Please ask for: Nicola Moore
Email: nicola.moore@arun.gov.uk
Telephone: Ext 37944
Our Ref: A/59/21/CLP
Your Ref:
Date: 31st March 2021

Lawful Development Certificate for a Proposed Use or Development

Development: Lawful development certificate for a proposed rear single storey extension, loft conversion and front porch.
Location: 10 Lambert Way Angmering BN16 4PE

BLOCK PLAN SCALE 1:200

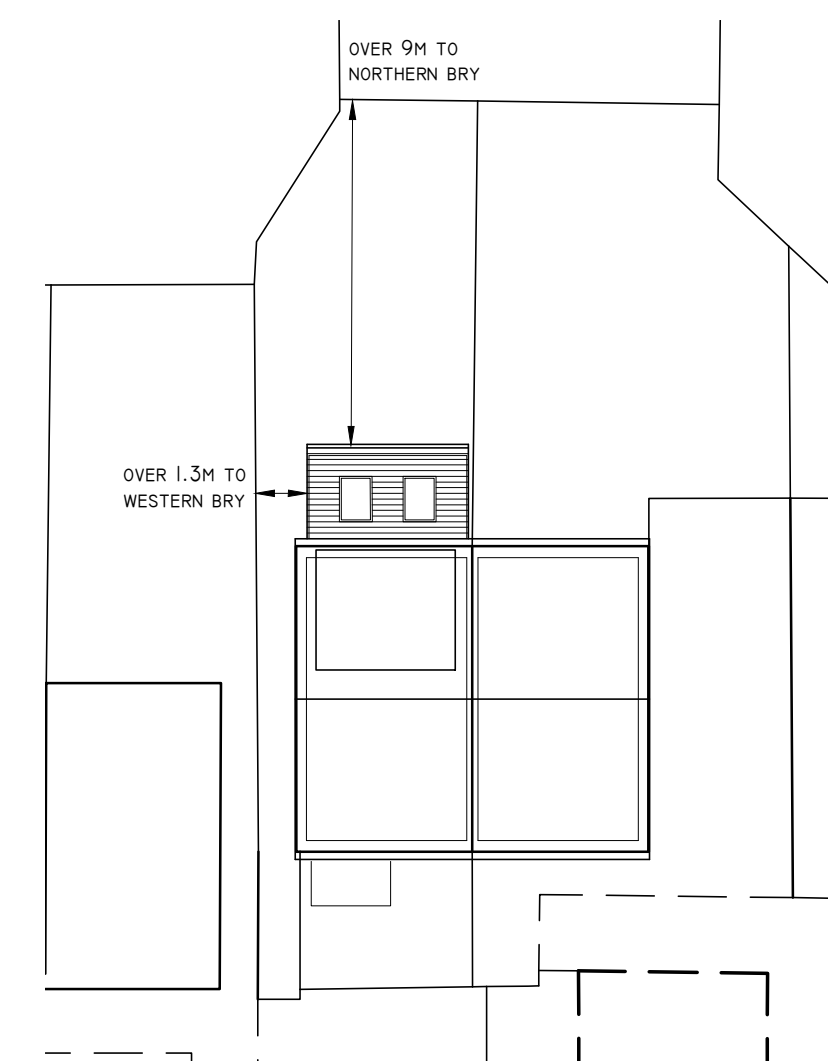
Block Plan

Please include the measurements from the proposed extensions to the boundaries and re submit.
